Summary of Written Representations
from the
Royal Society for the Protection of Birds

**Submitted for Deadline 1
18th November 2025**

**Application by National Grid Electricity Transmission for the
Sea Link Project**

**Planning Inspectorate Ref: EN20026
The RSPB Registration Identification Ref: F5280E651**

nationalgrid					
Scheme: SEA LINK					
Document Title: SUFFOLK WINTERING BIRD TRANSECT ROUTES 2022-23					
Creator: EB	Date: 04/02/2025	Checker: DF	Date: 04/02/2025	Approver: SG	Date: 04/02/2025
Document Ref: FIGURE 6.4.2.2.B.1	Scale: 1:30,000	Format: A3	Sheets: OF	Rev: 0

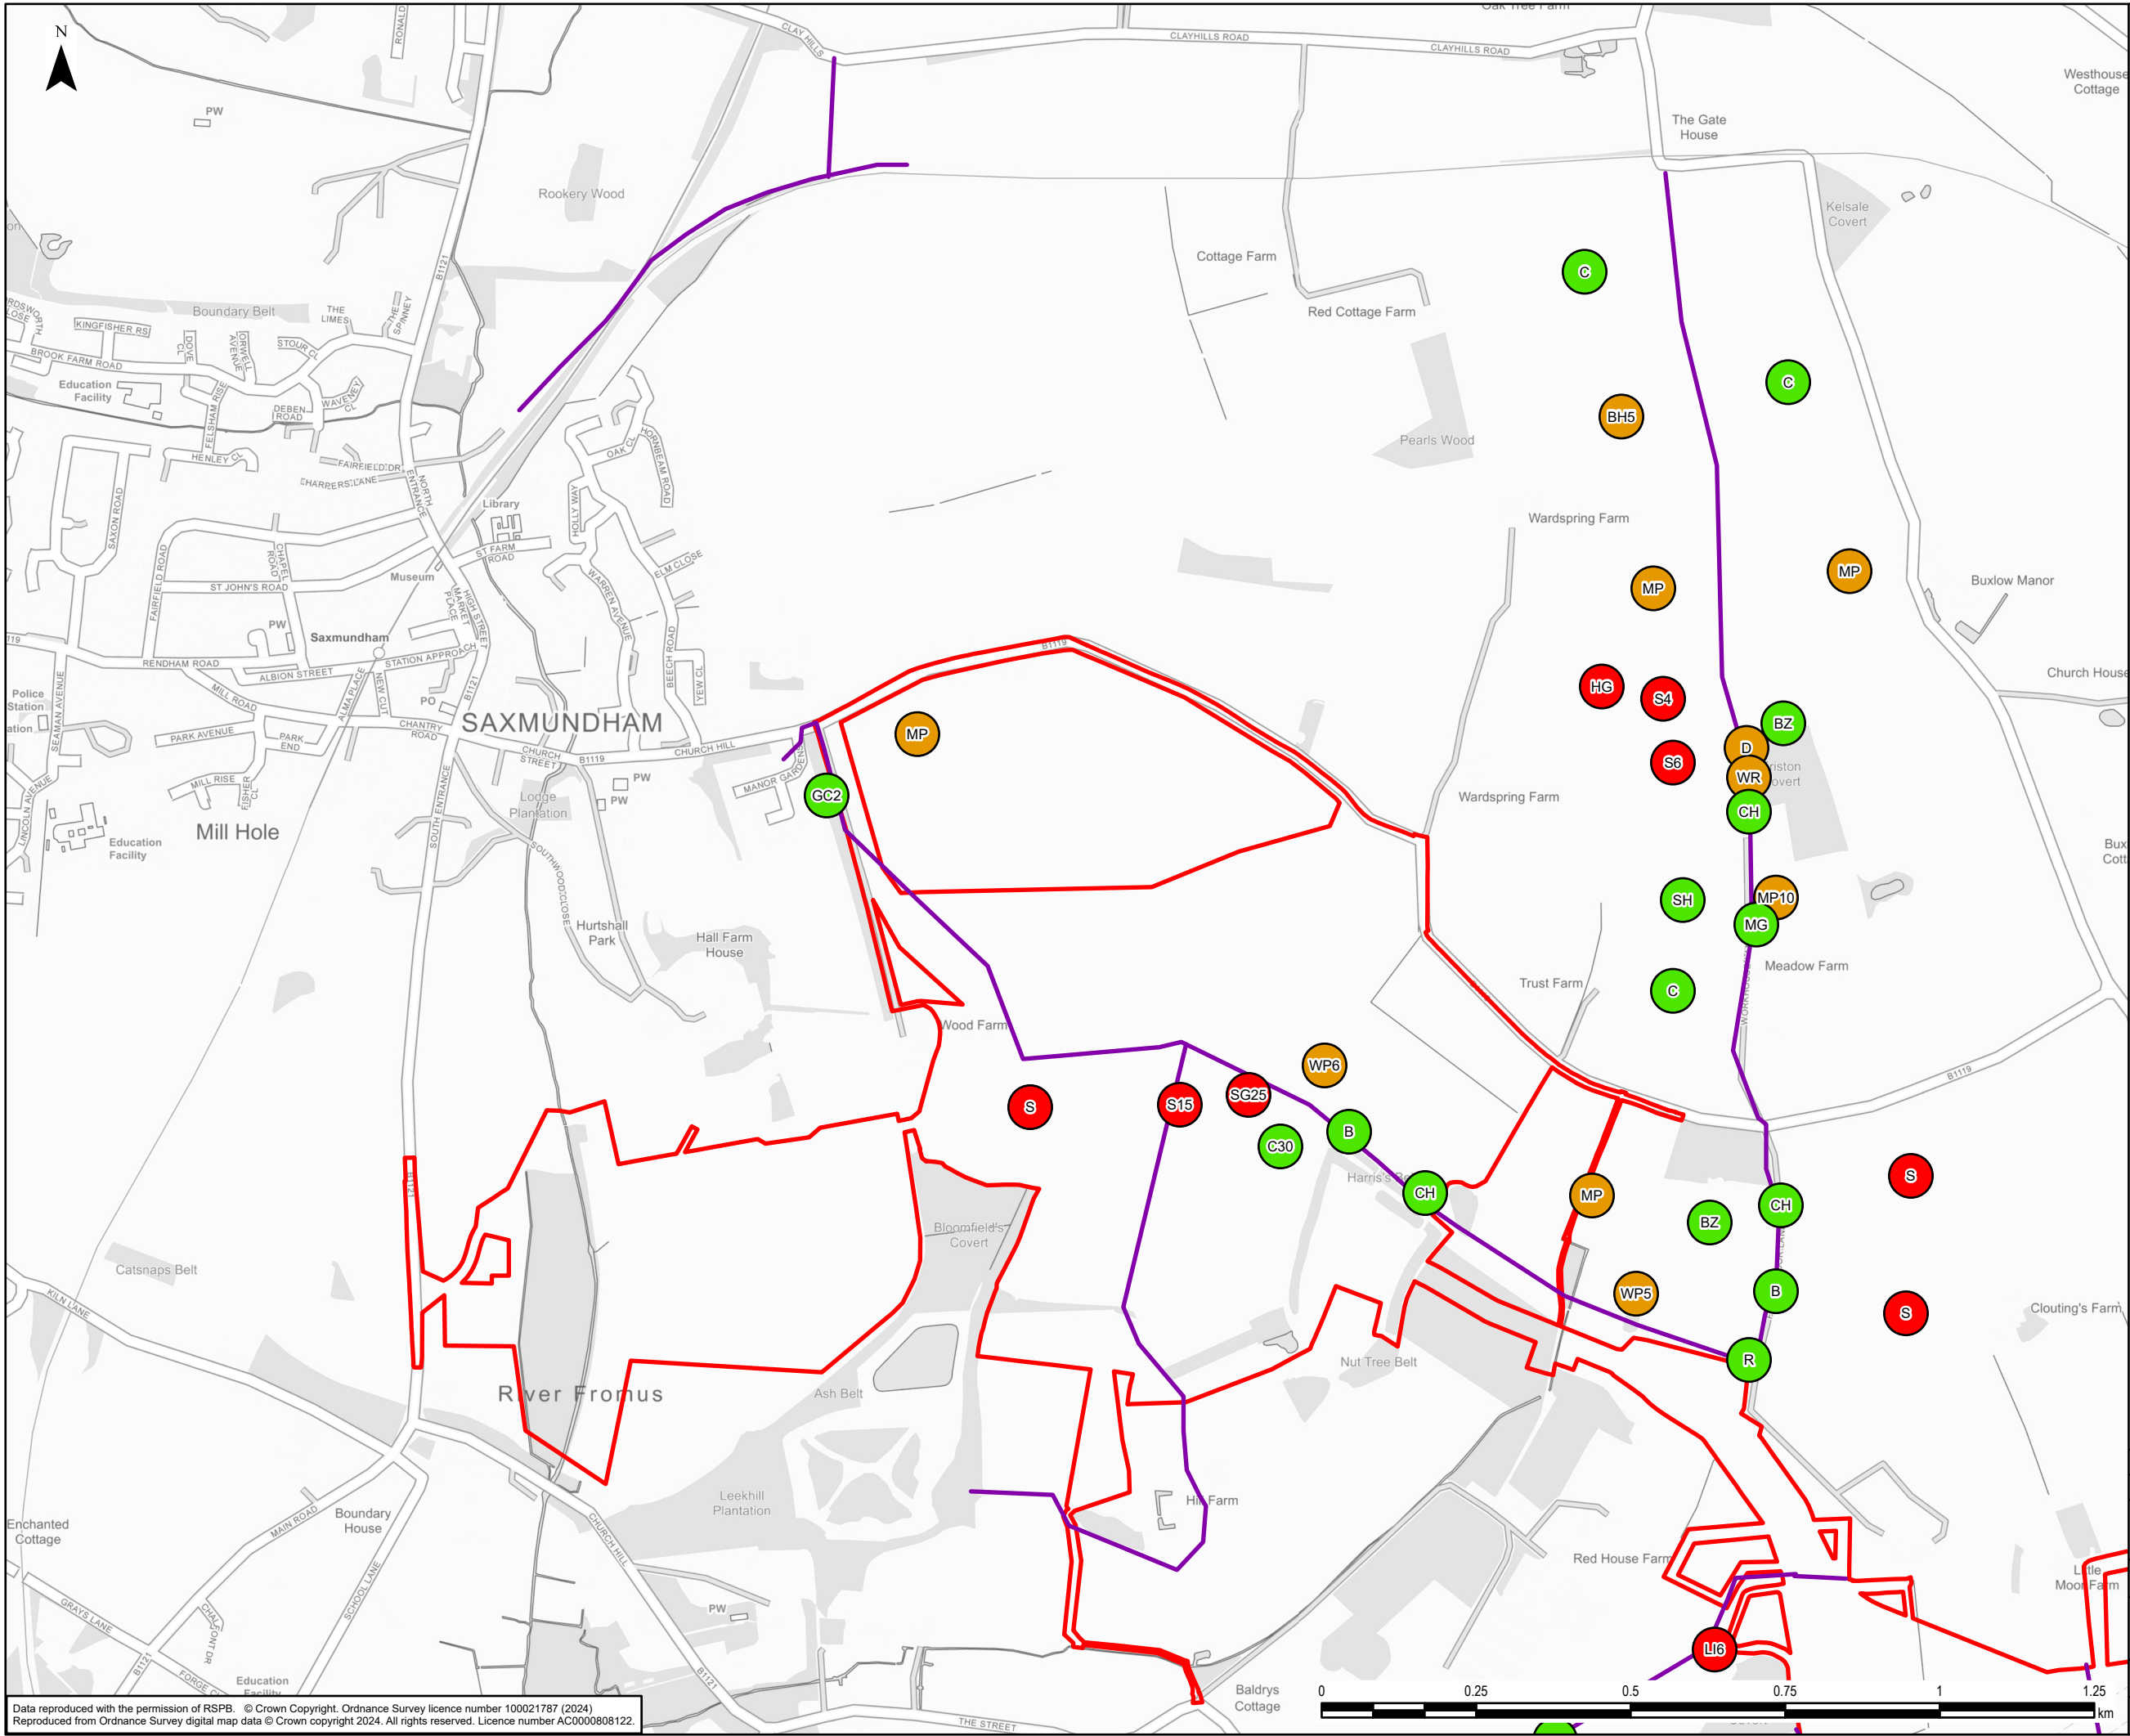
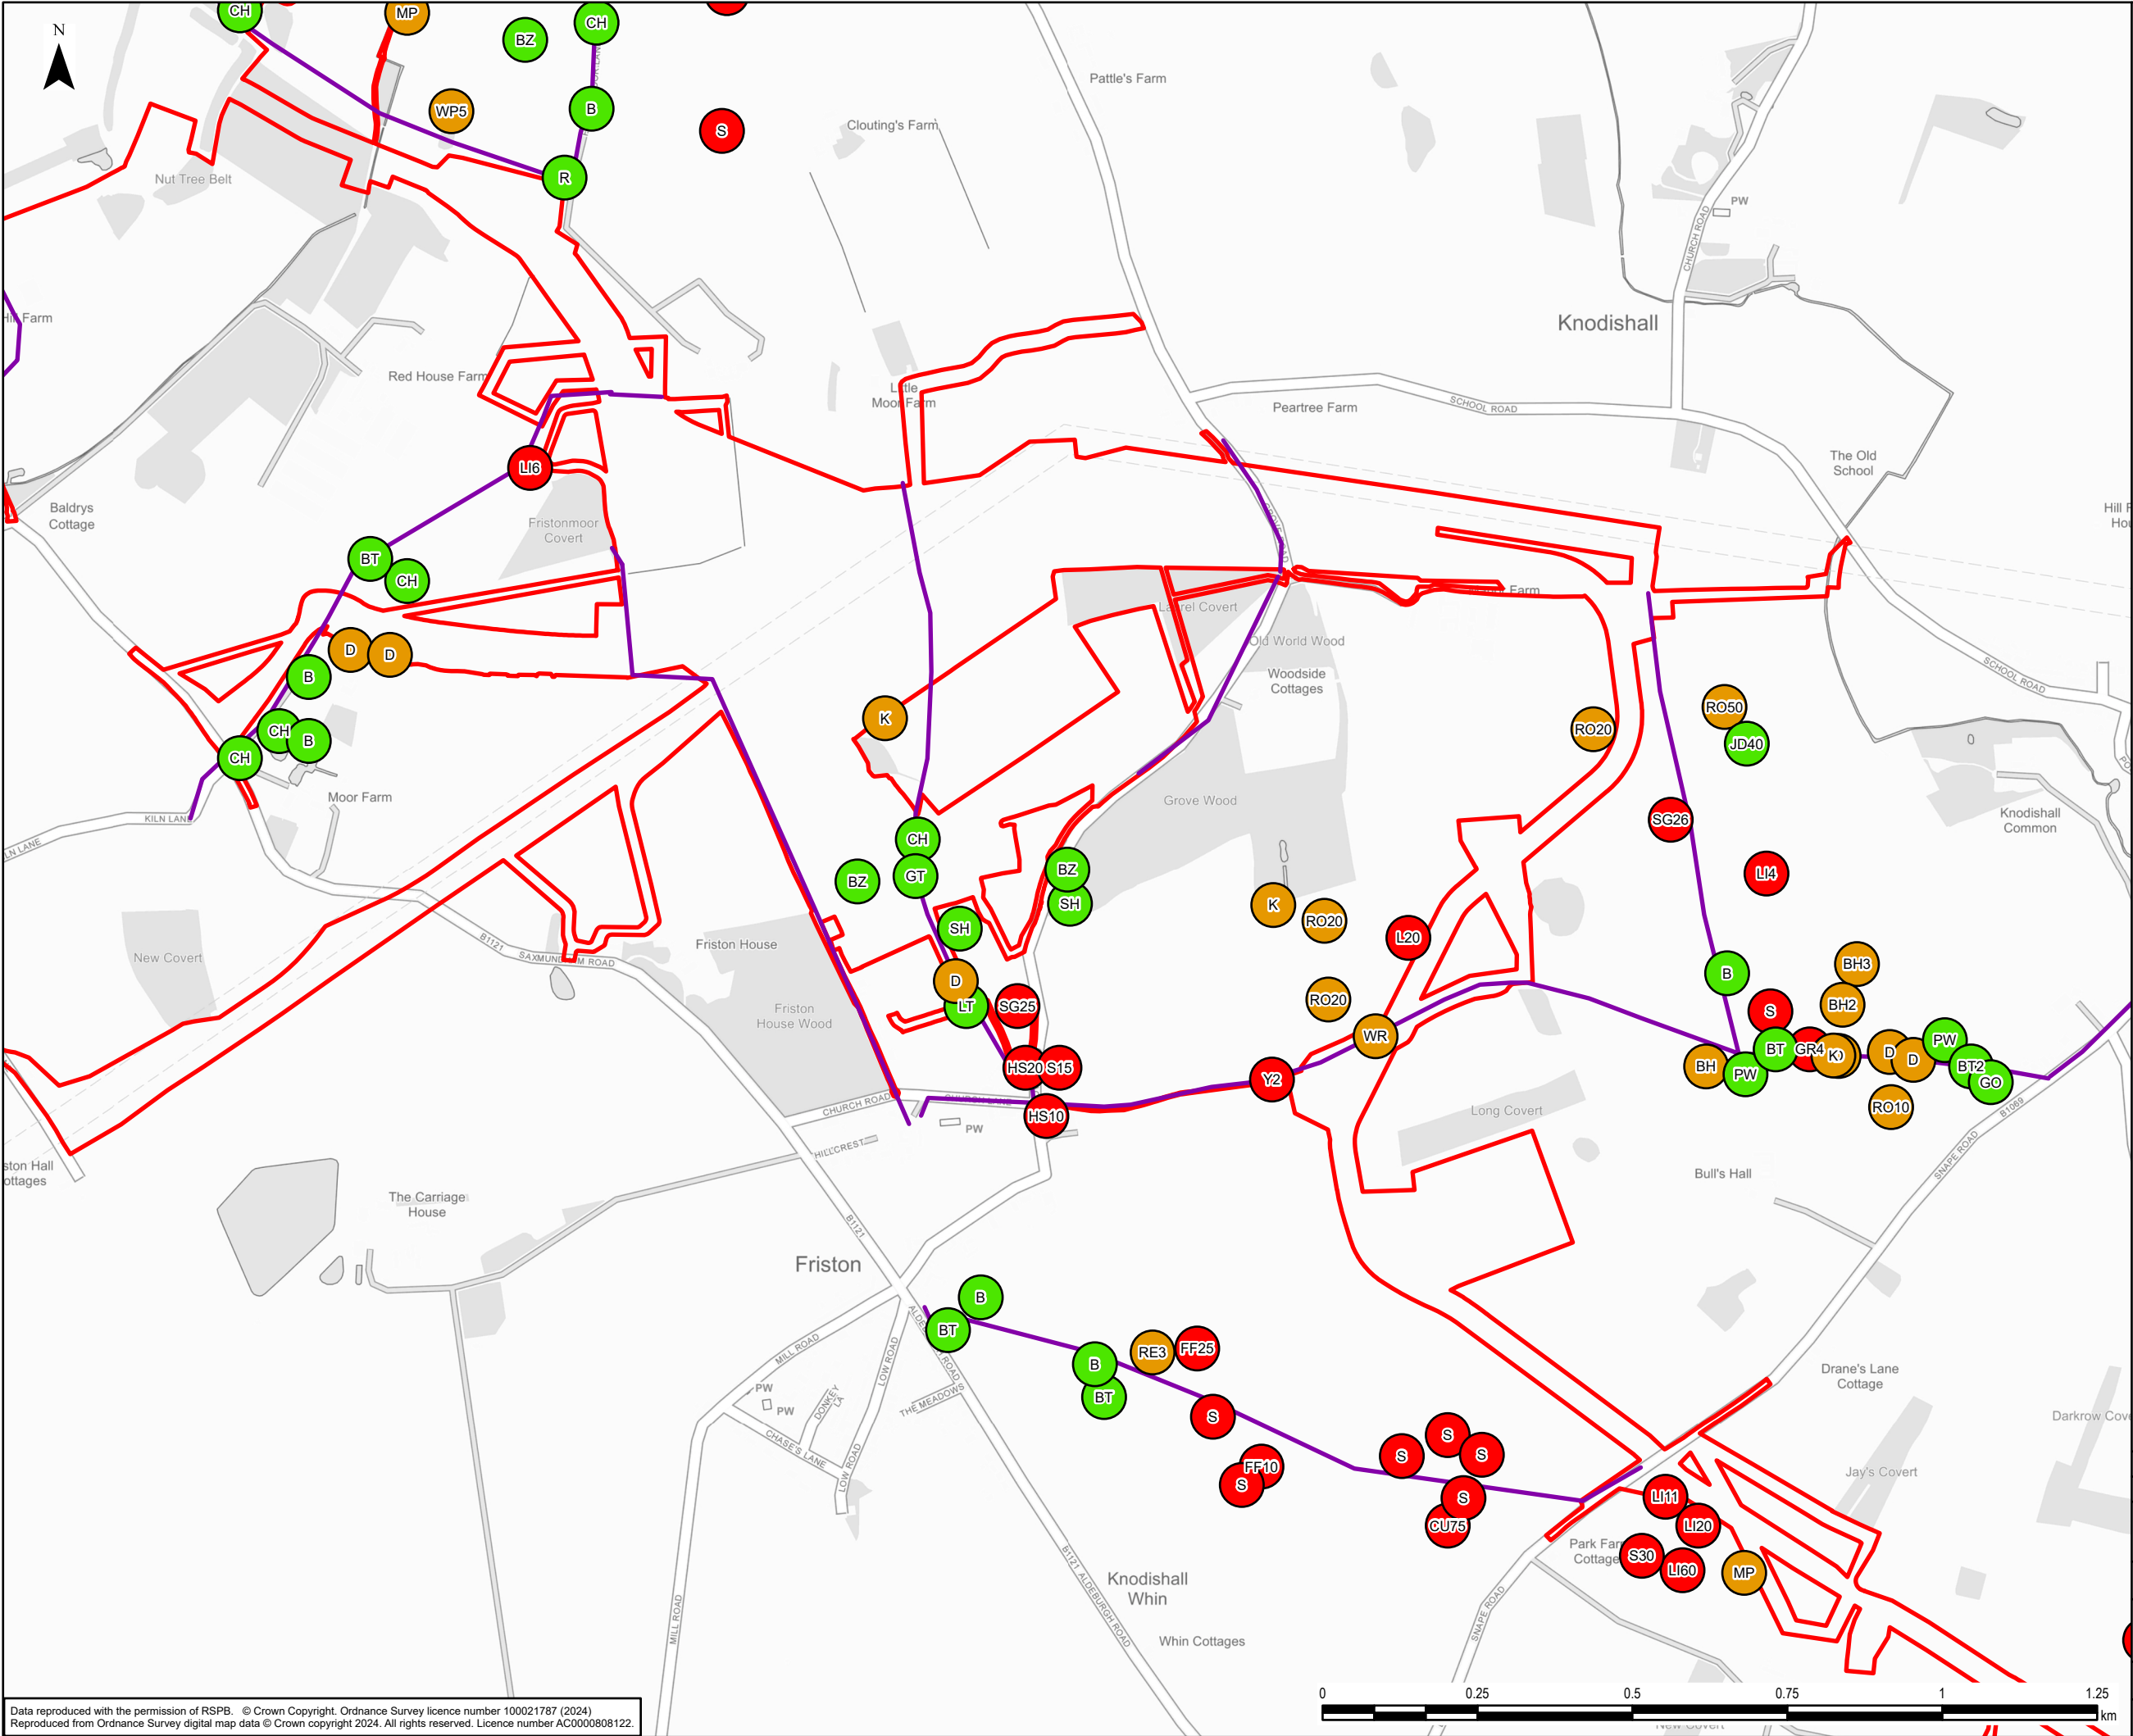
- For the 2024 Lapwing and Redshank figures, methods and limitations should be discussed and it should be acknowledged that the territory distribution maps may not accurately reflect the real locations of favoured areas.
- Maps used to show the abundance and distribution of wintering birds recorded during 2022/23 in [APP-216](#) should clearly indicate that the wet grasslands were not formally surveyed on the dates shown in the legend.
- Annex 2.B.2 (p63, ep67) of [PDA-025](#) ES Appendix 2.2.B Suffolk Wintering Bird Report is a compendium of WeBS data from Kent and not Suffolk and requires correction.
